# WALDEN PRESERVE 2

## Filing No. 4

# Grading & Erosion Control Plans

PCD FILE NO. SF-18-034

SHEET: **C1**

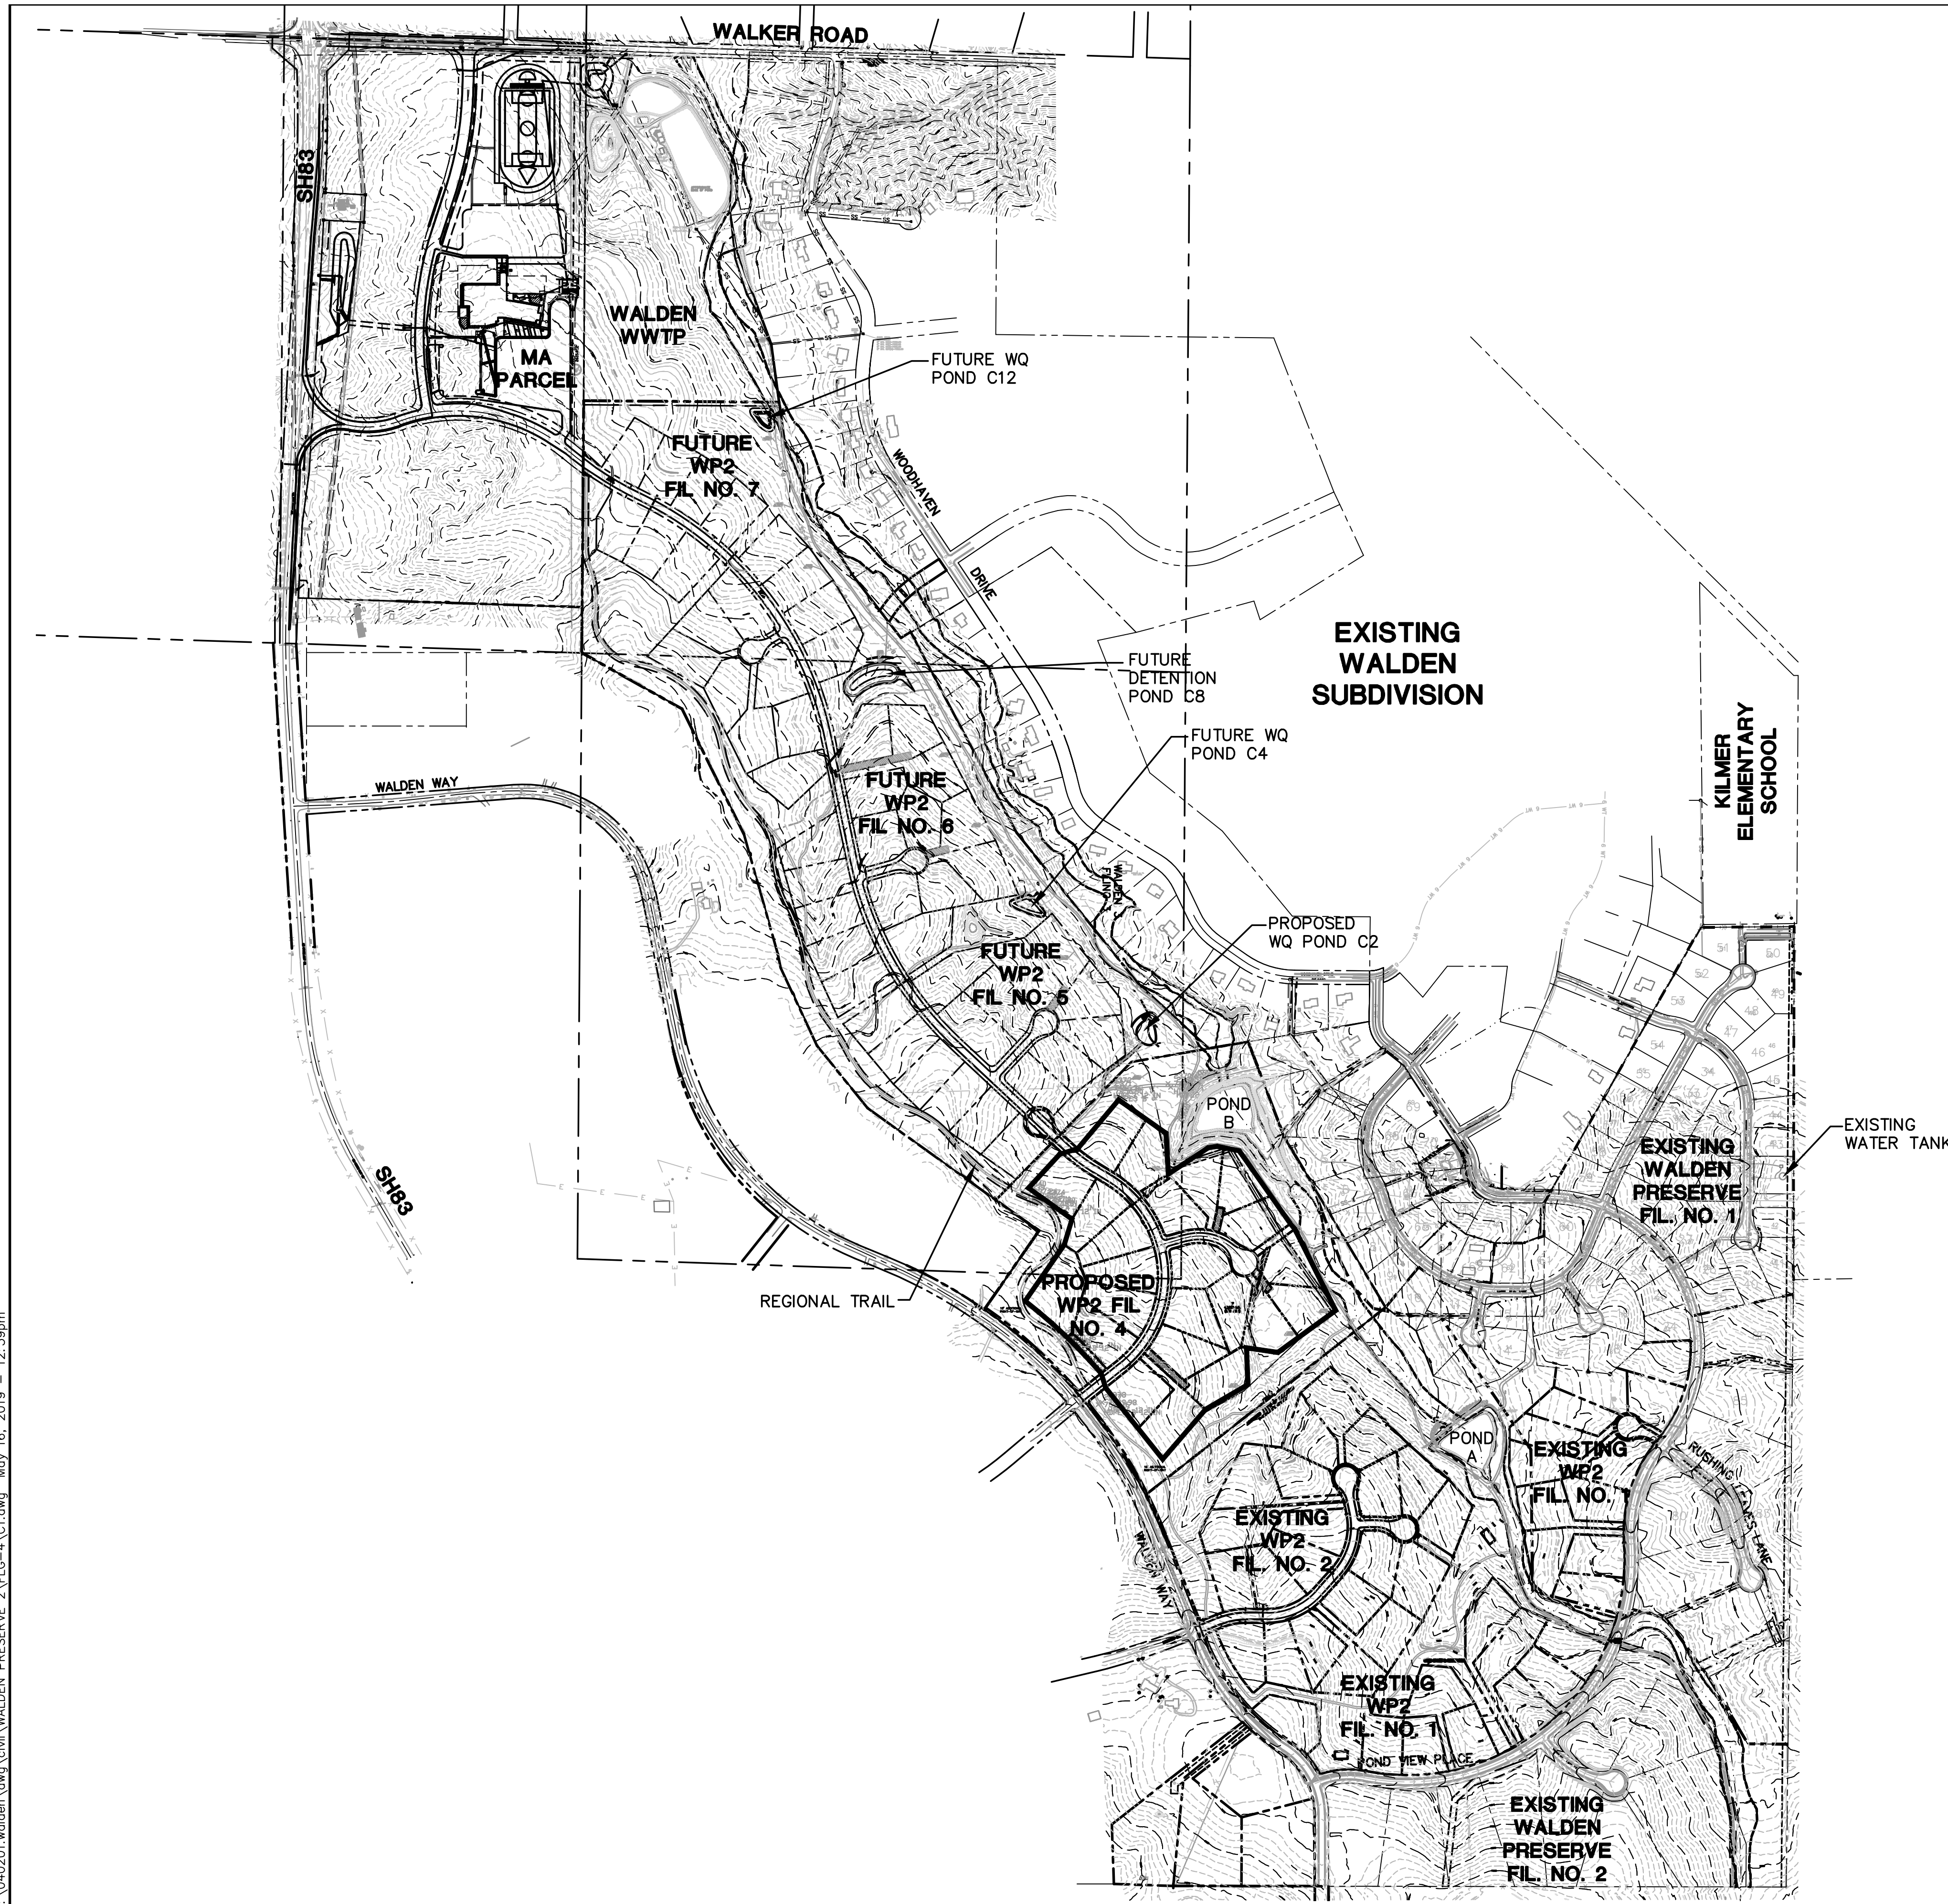
Update. Discrepancy with the FDR Driveway Culvert Summary

SHEET: **C1.1**

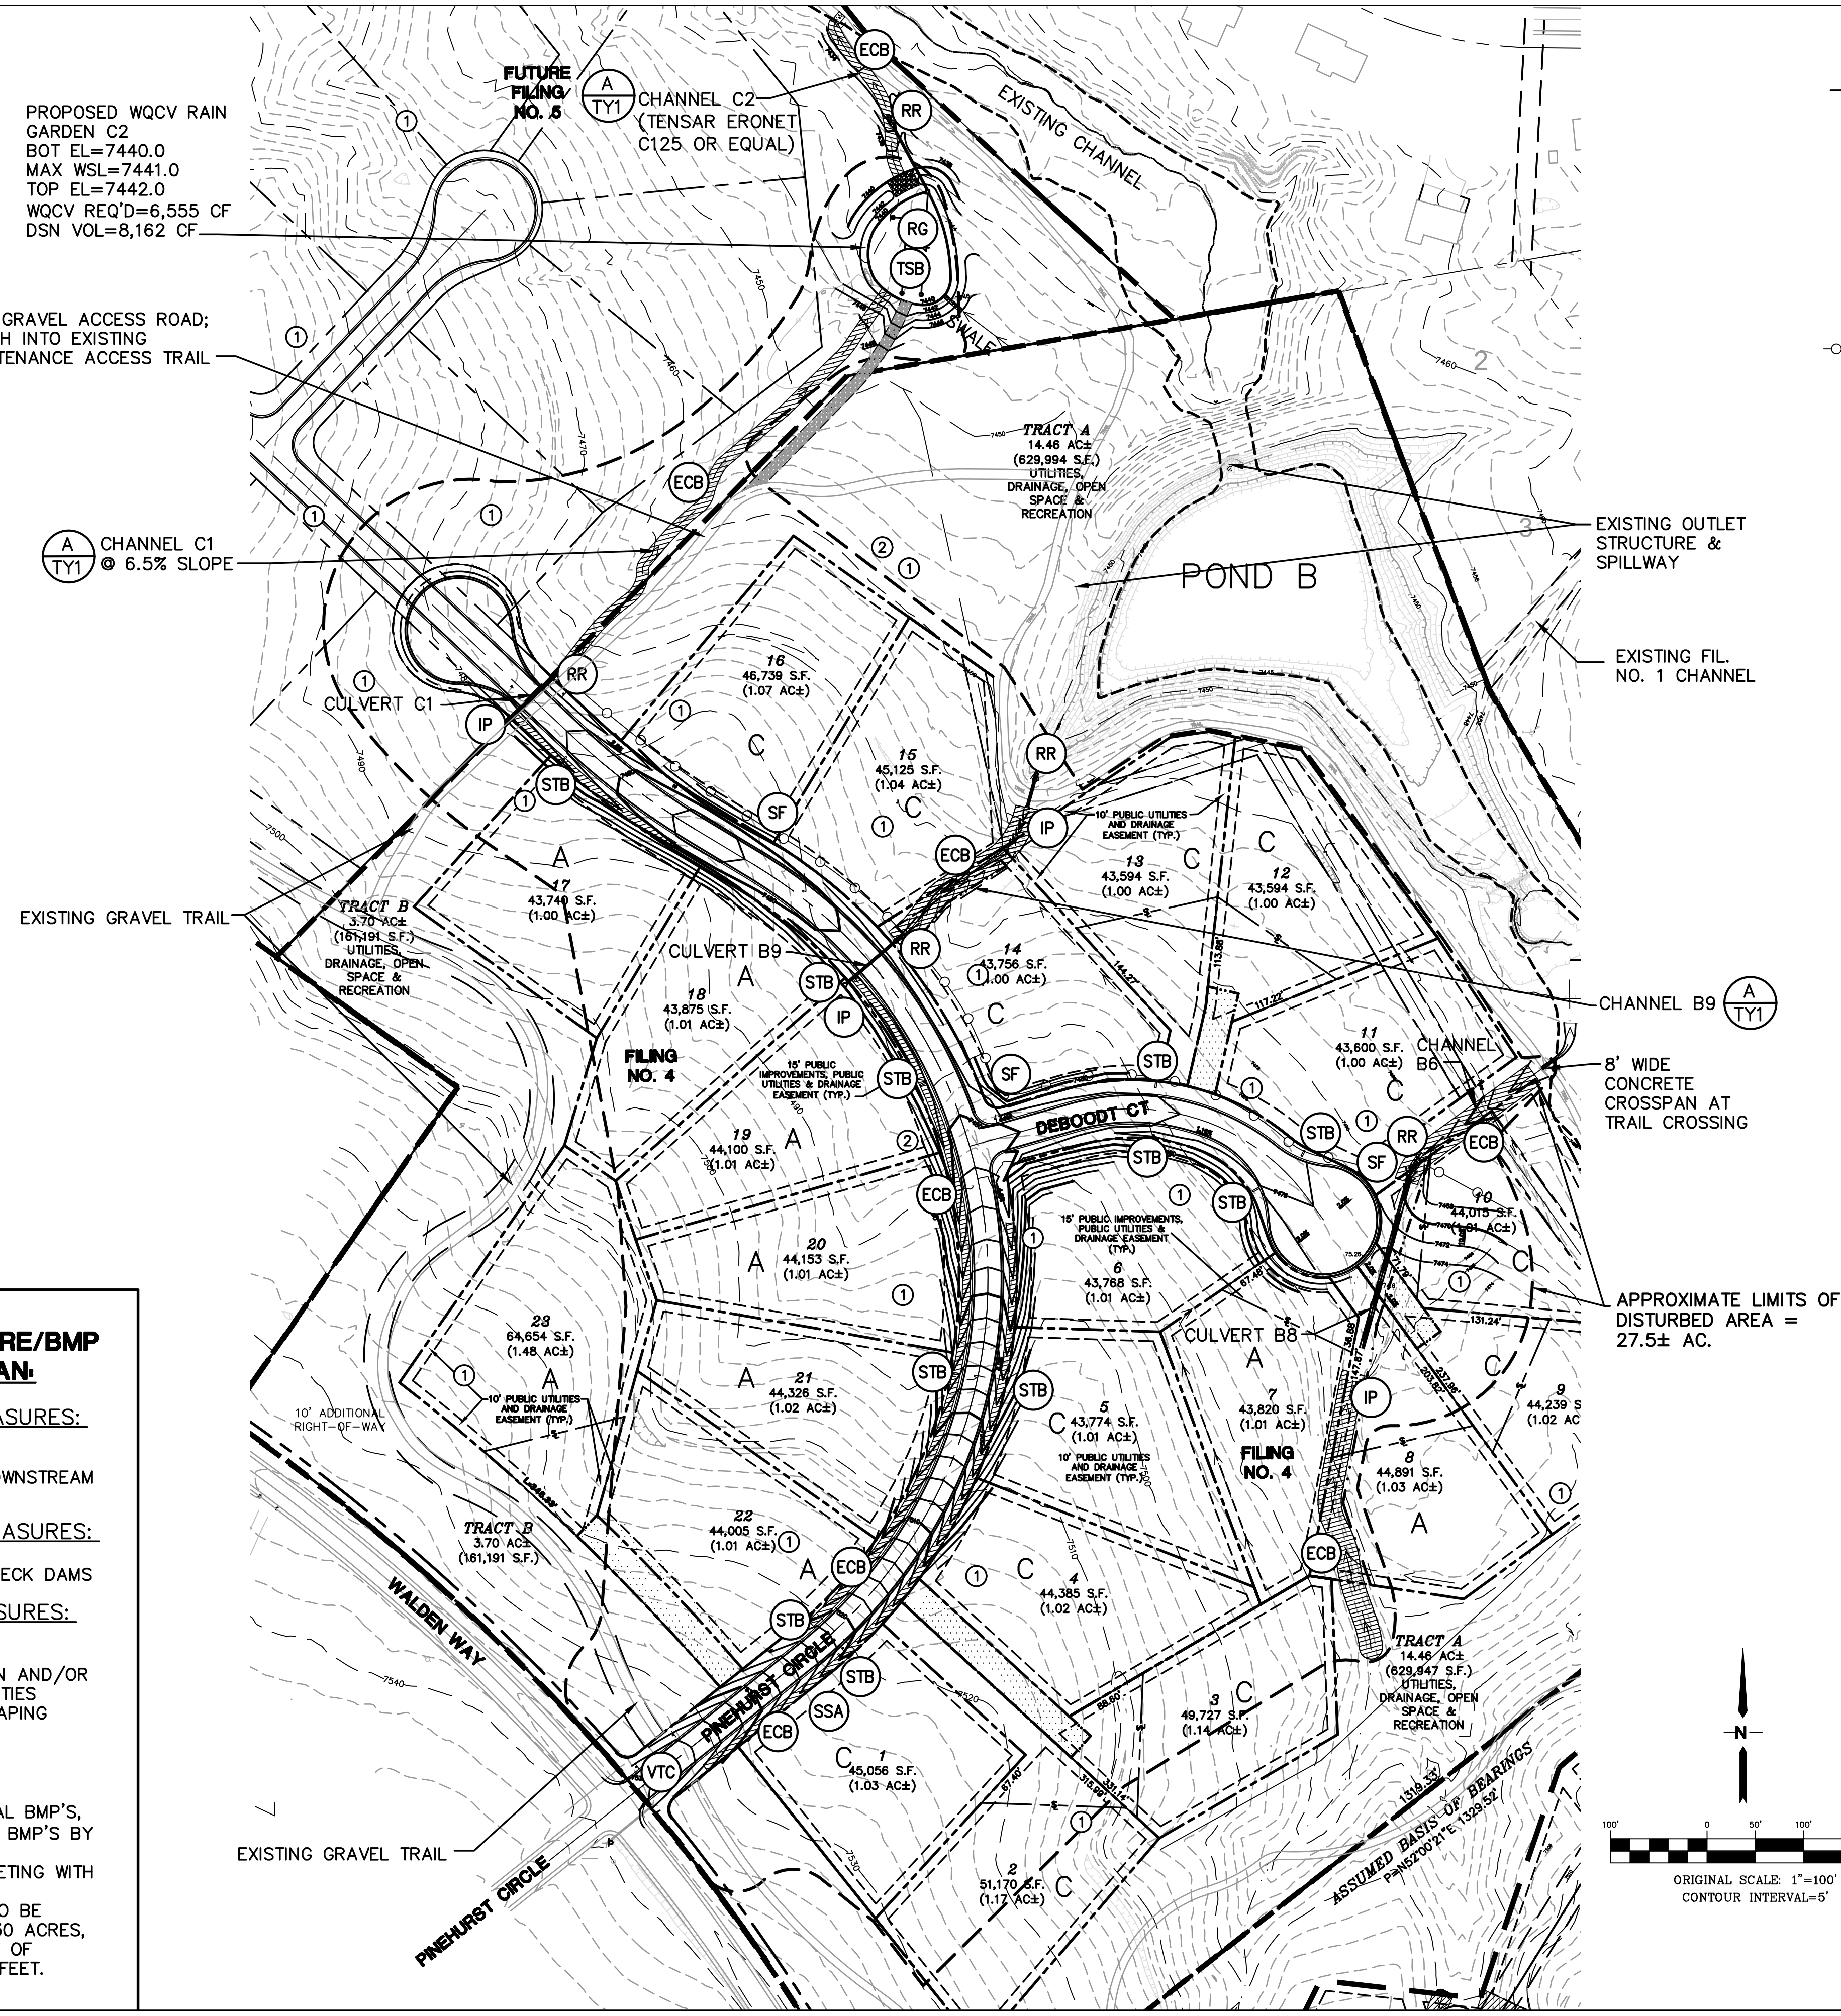
Identify the specific product used or approved equal.
